East Anglia ONE North and East Anglia TWO Offshore Windfarms

Applicants' Comments on Tessa Wojtczak's Deadline 8 Submissions

Applicant: East Anglia TWO and East Anglia ONE North Limited
Document Reference: ExA.AS-15.D9.V1
SPR Reference: EA1N_EA2-DWF-ENV-REP-IBR-001044

Date: 15th April 2021
Revision: Version 1
Author: Royal HaskoningDHV

Figure 1 Potential Sensitive Receptors and Areas Subject to Additional Construction Phase Controls

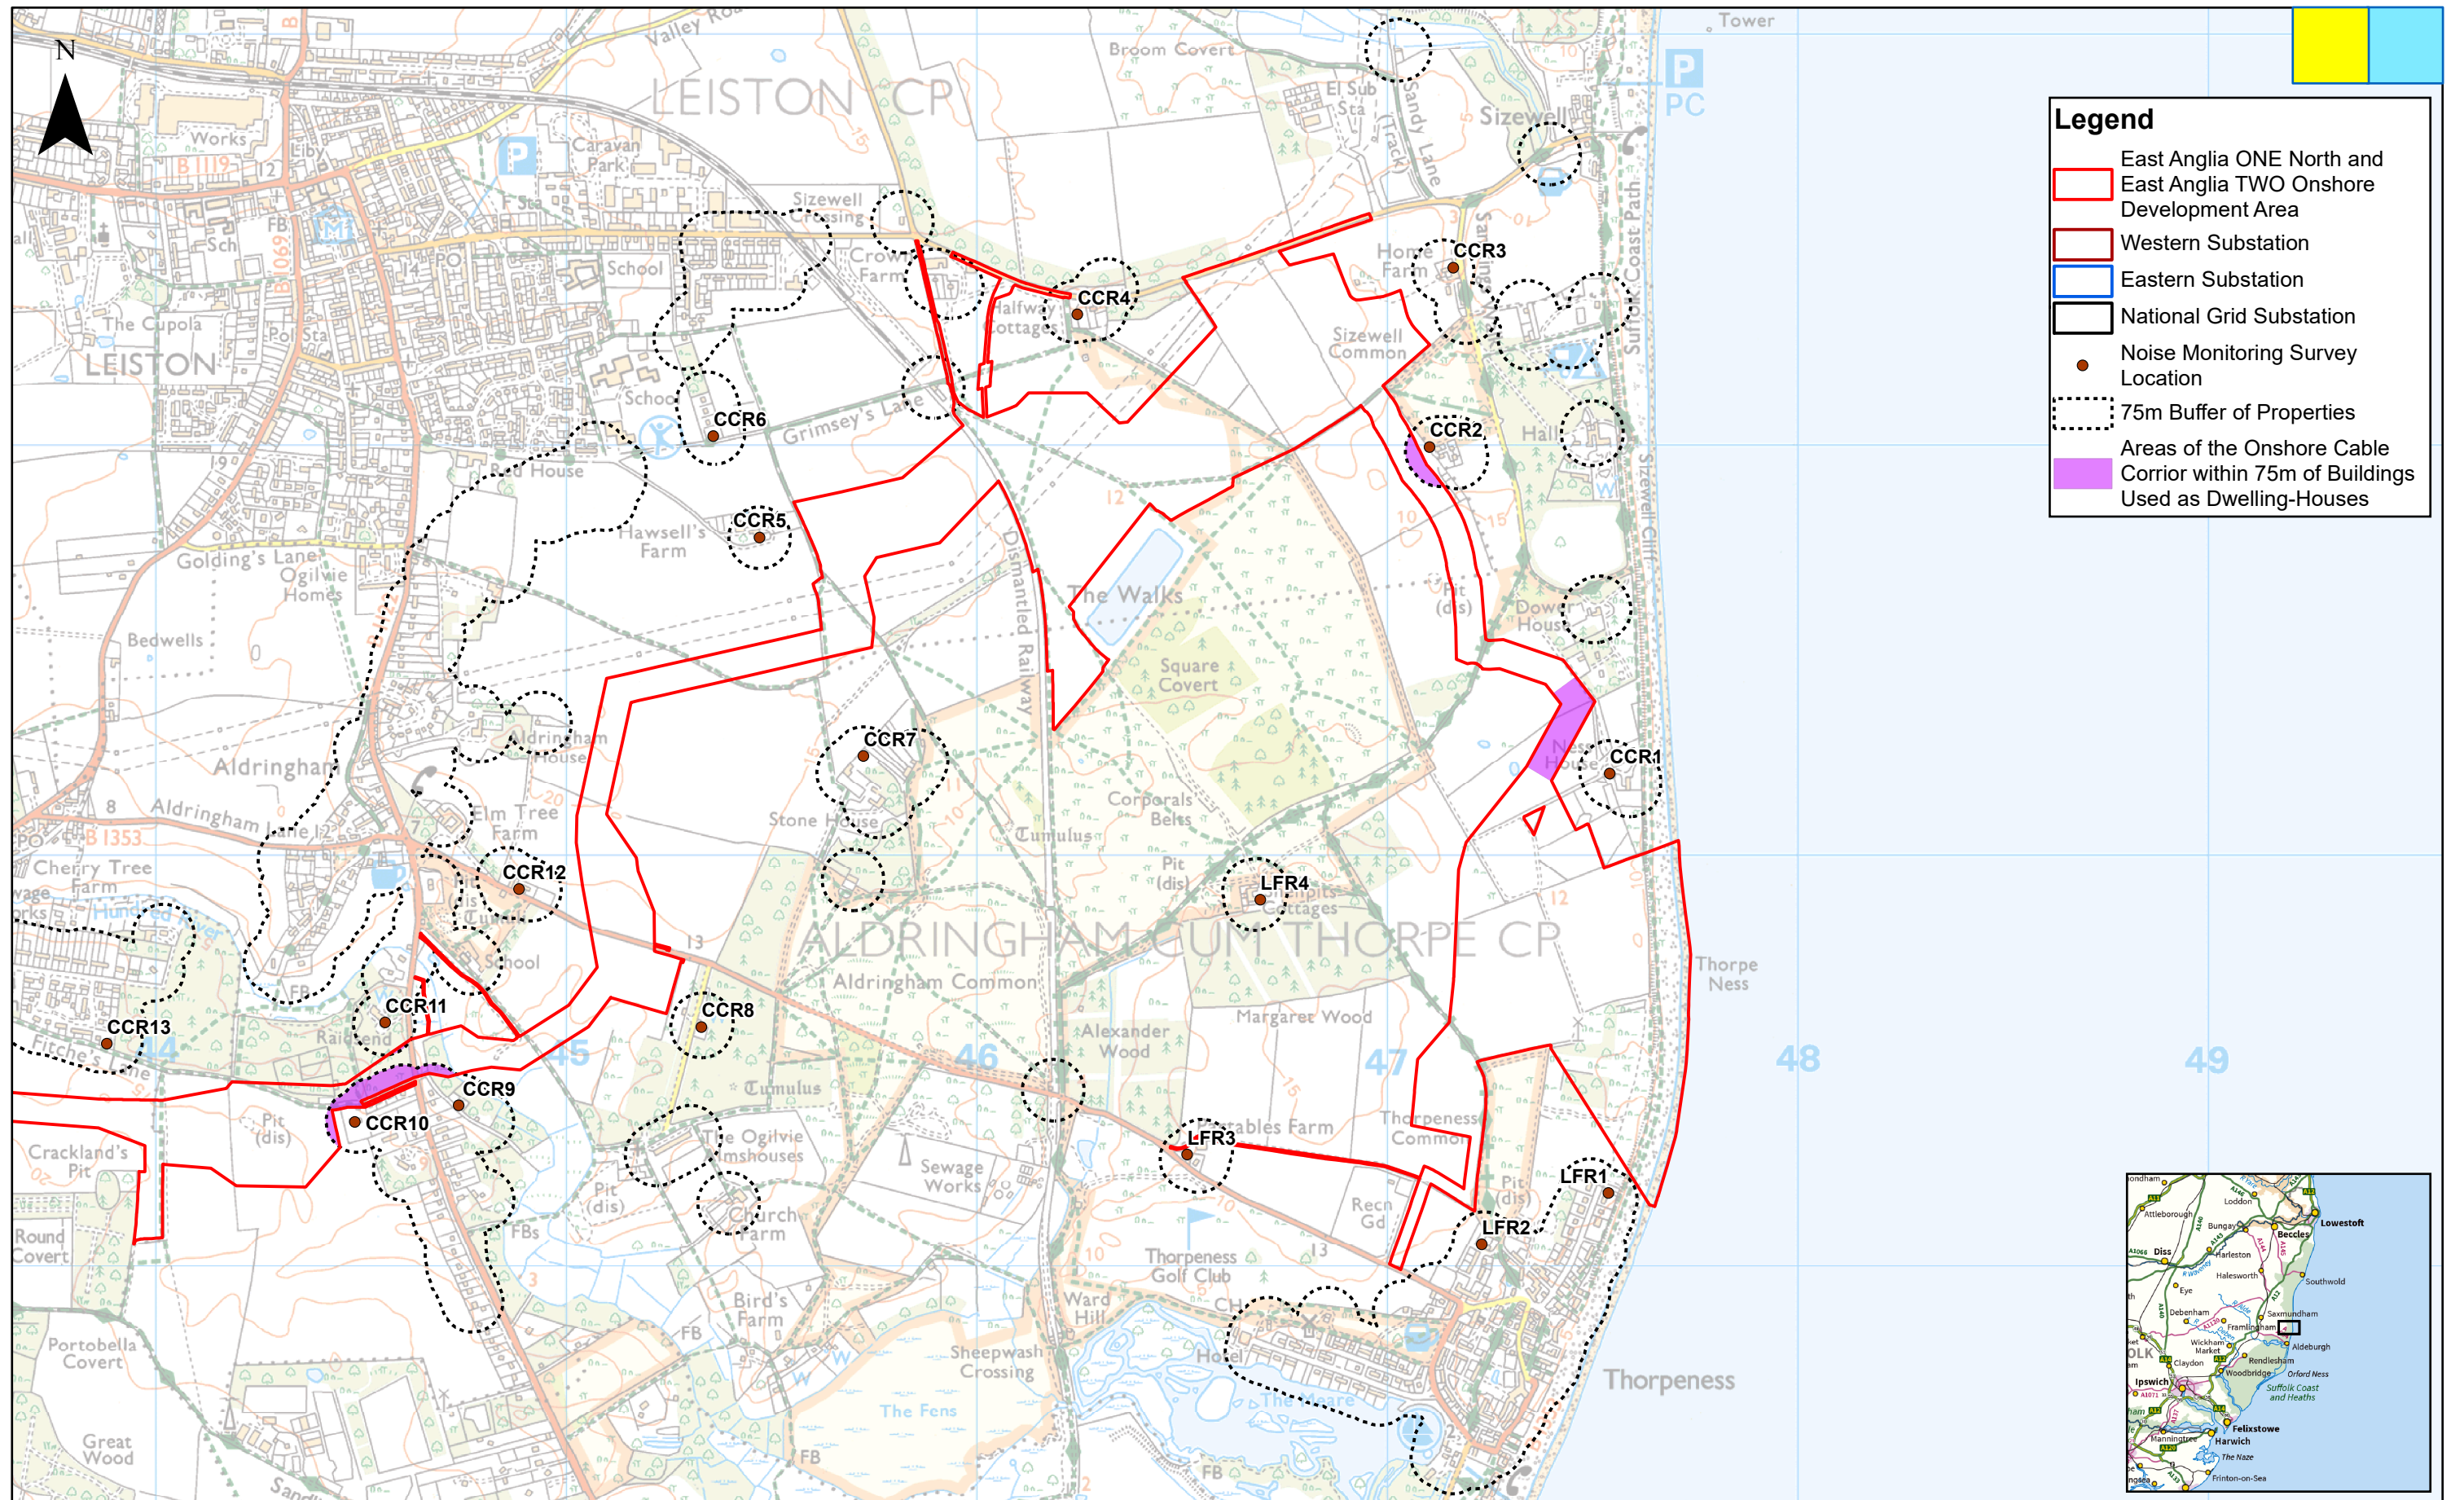
8	<p><u>Appendix 2 Figure 1. Potential Sensitive Receptors and Areas Subject to Additional Construction Phase Controls. Map.</u></p> <p>In my Deadline 1 WR, I drew the Examining Authority's attention to the inaccurate identification of a Noise Monitoring Survey Location directly westward of the garden gate of [REDACTED],</p>	<p>As per Appendix 23.3 of the ES (APP-524), the Applicants note that the property taken as the closest noise sensitive receptor to the Order limits was [REDACTED] located at the coordinates presented with Table A25.3.4. This was agreed prior to the surveys being undertaken with the Expert</p>

ID	Tessa Wojtczak Comment	Applicants' Comments
	<p>identified on the map referenced above as CCR1. This point was also raised by [REDACTED] at ISH 4 Day 2.</p> <p>To quote from my Deadline 1 submission:</p> <p><u>“ 6. Noise and vibration management. ExAQ 1.4.34 Baseline Measurements Flaw/ inaccuracy in assessment studies.</u></p> <p>On 20 June 2018 I was notified via my landlord’s agent of the Applicant’s proposal to place 3 briefcase sized noise monitors and 1.5 metre poles in the hedge/ scrubby trackside areas for noise monitoring at some point for 7 days commencing at some point in the next 3 weeks. Please see attached email screenshot.</p> <p>An aerial photo was attached showing clearly that the monitors would be sited directly at the bottom of our garden, with a picture of the monitors in question . These are the monitors identified as CCR 1 in Appendix 2, Figure 1. In fact, as the Baseline Noise Monitoring Tables show (APP-524) they are identified with another property at a different location, [REDACTED]</p> <p>[Please refer to REP8-246 for images referred to above]</p> <p>These monitors did not appear.</p>	<p>Topic Group (ETG) for noise, which comprised the Environmental Health Officer for East Suffolk Council at the time.</p> <p>For CCR1, the noise monitoring equipment was positioned near to the west façade of [REDACTED]</p> <p>The Applicants note that there appears to have been a miscommunication to Ms Wojtczak during the course of consultation regarding the baseline noise surveys. The Applicants only ever undertook (and indeed intended to undertake) attended short-term monitoring at the landfall and onshore cable route receptors, whereby equipment was deployed under supervision by the surveyor for a period of 30-minutes during the day and for a period of 15-minutes during the night time. Due to the parameters of the survey timings, it is entirely possible that residents of neighbouring properties did not witness the surveyor or survey equipment. Furthermore, given the siting of the survey on the west façade of [REDACTED] it is noted that the view of any such survey from [REDACTED] would have been obscured by the cottages located between the survey location and that property.</p>
